DOC22/330403

**Planning Referral – Aurelia Metals Ltd for Federation Project Hera Resources Pty Ltd
State Significant Development SSD-24319456**

The EPA has reviewed the Environmental Impact Statement titled "Federation Project, State Significant Development (24319456), Environmental Impact Statement" prepared by SLR Consulting Pty Limited on behalf of the Proponent dated January 2022 and accompanying attachments. The EPA has provided recommended conditions of approval and general comments in Attachment A.

Figure 6-1: Location of emission sources(a) – Hera Mine

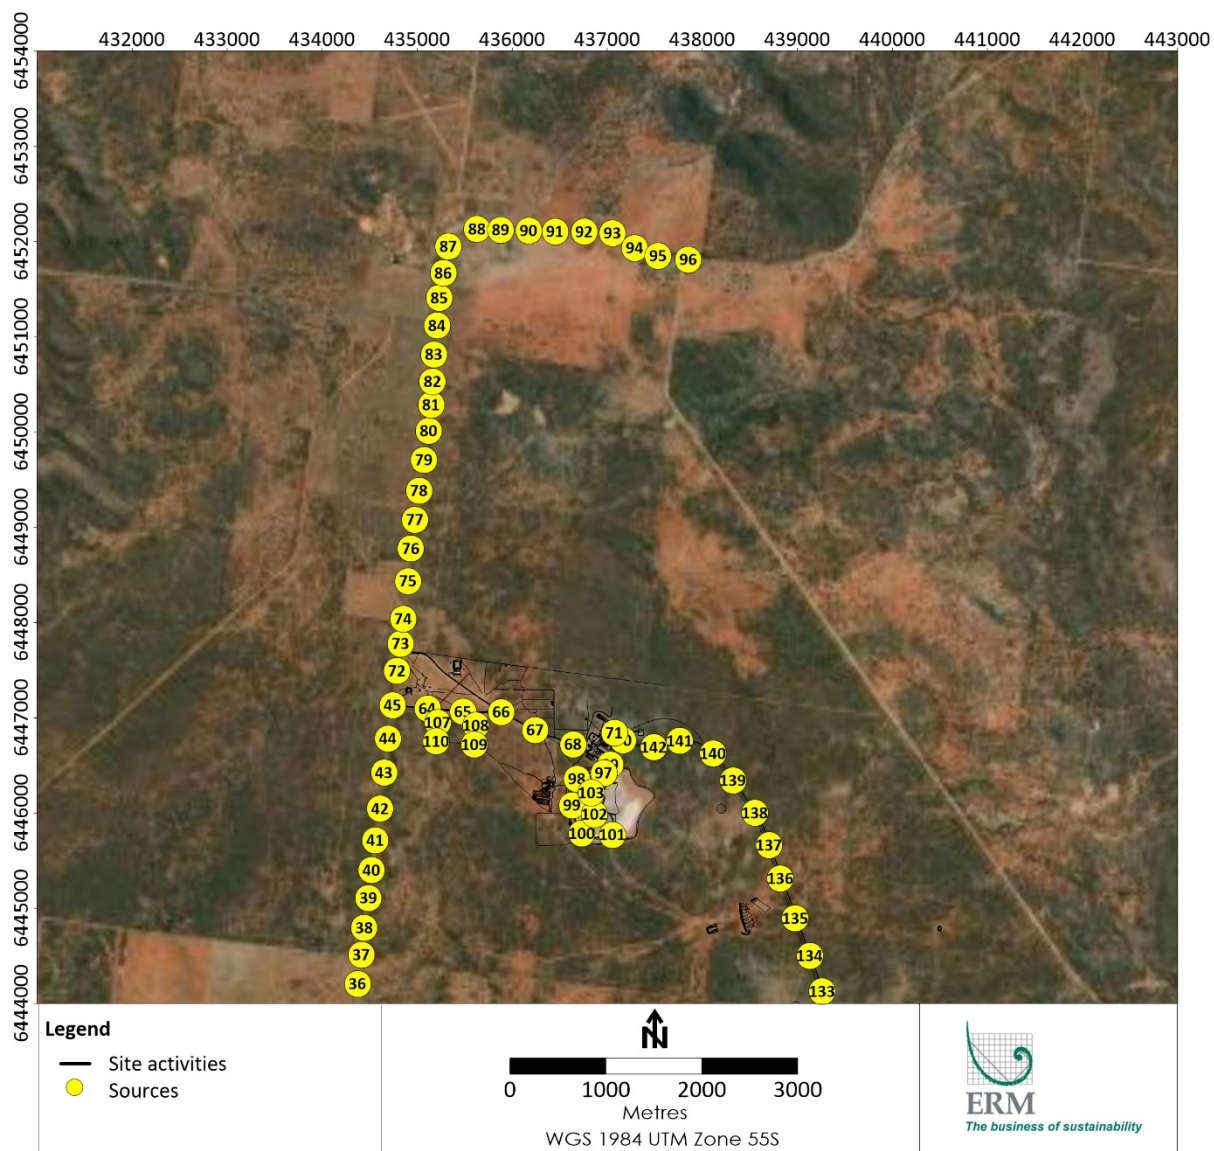
1. The EPA requests that the Proponent provides additional information to describe the activities undertaken at both the Hera Mine and Federation site, including the processing circuit, to demonstrate that the Air Quality and Greenhouse Gas Impact Assessment (AQIA) has accounted for all significant emission sources.

The Hera Mine and Federation site are inherently interlinked and will be covered by one environment protection licence. While the AQIA states that the “processing of ore will only take place at the Hera Mine, therefore is outside the scope of this project”, it is noted that the Proposal will produce ore within current development approvals in relation to the (505,000 tpa) and that the AQIA has assessed cumulative impacts due to activities undertaken at both projects, including the processing circuit. However, the AQIA does not include a detailed description of the activities undertaken at the Peak complex including the processing circuit and therefore it is unclear whether all relevant emission sources from this facility have been assessed.

Figure 6-2: Location of emission sources(b) – Federation Site

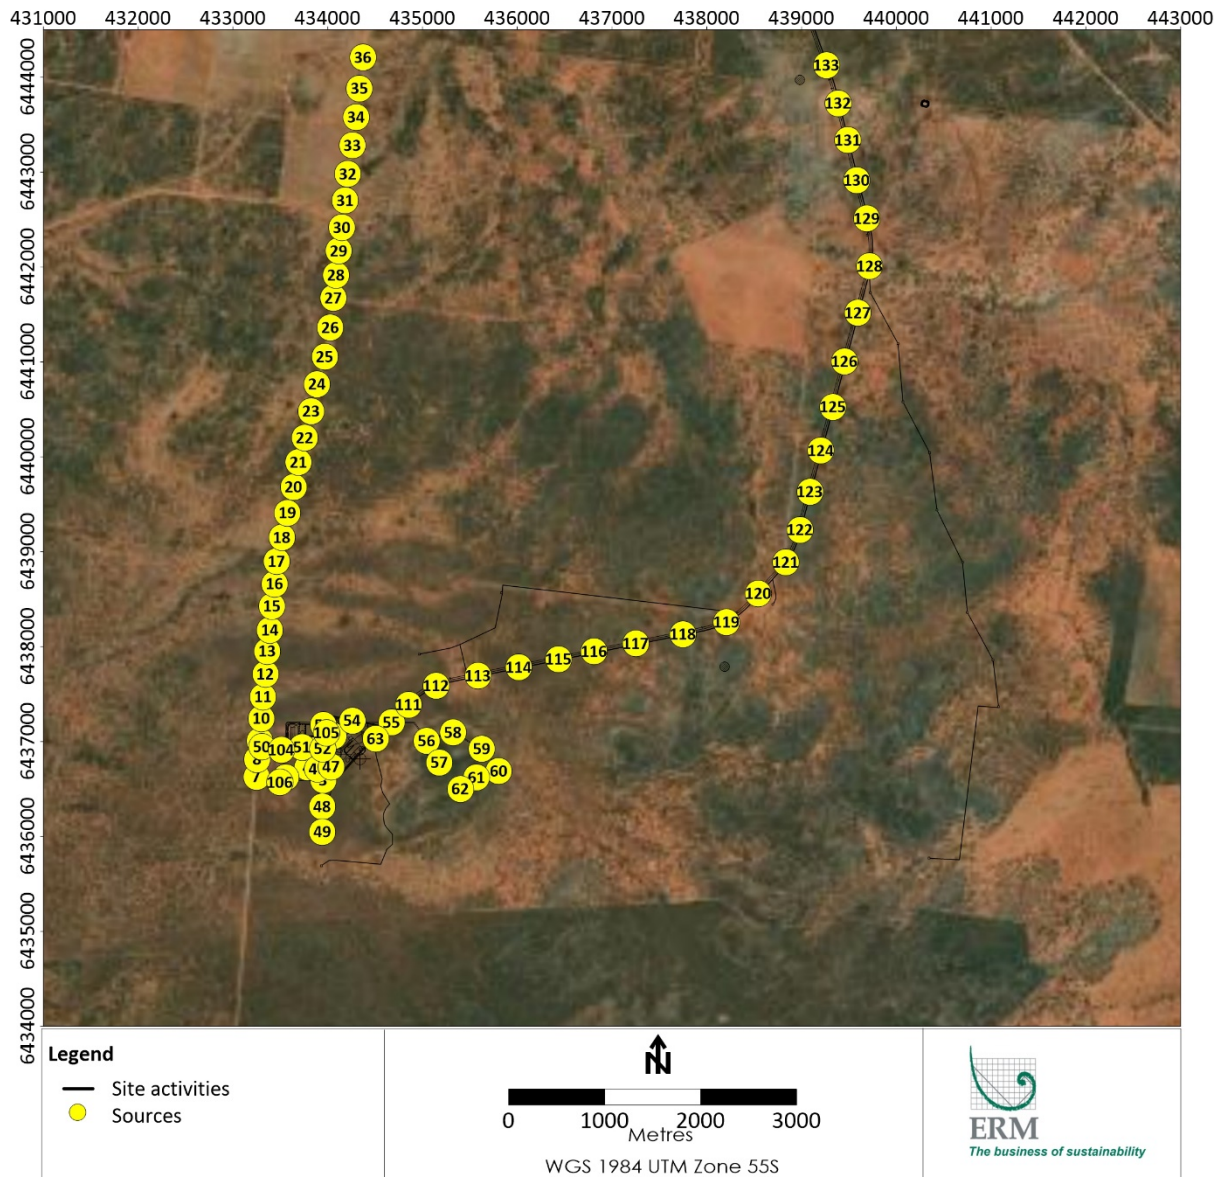
2. The EPA requests that the Proponent revises the AQIA to benchmark the proposed mitigation measures against best practice dust control measures.

It is noted that the AQIA does not predict additional exceedances at any of the identified privately owned receptor locations and that it includes mitigation measures primarily through the use of water for dust suppression. Nonetheless, considering the location of all receivers a detailed review of best practice dust control measures is necessary to demonstrate that the proponent has evaluated and/or committed to all reasonable and feasible mitigation measures to prevent and minimise air pollution. Particular emphasis should be given to the largest emissions sources such as the proposed ventilation shaft, the existing ventilation shafts, and activities related to hauling and wind erosion. The EPA is seeking that the AQIA give consideration to, but need not be limited to, the following:

- Any measures to minimise emissions from the ventilation shafts, including those that can be implemented when undertaking underground works; and
 - The use of chemical suppressants to reduce emissions from haulage on unpaved roads.
3. The EPA recommends that the Proponent nominates and commits to the implementation of mitigation measures during the construction phase of the Proposal, if approval is granted.
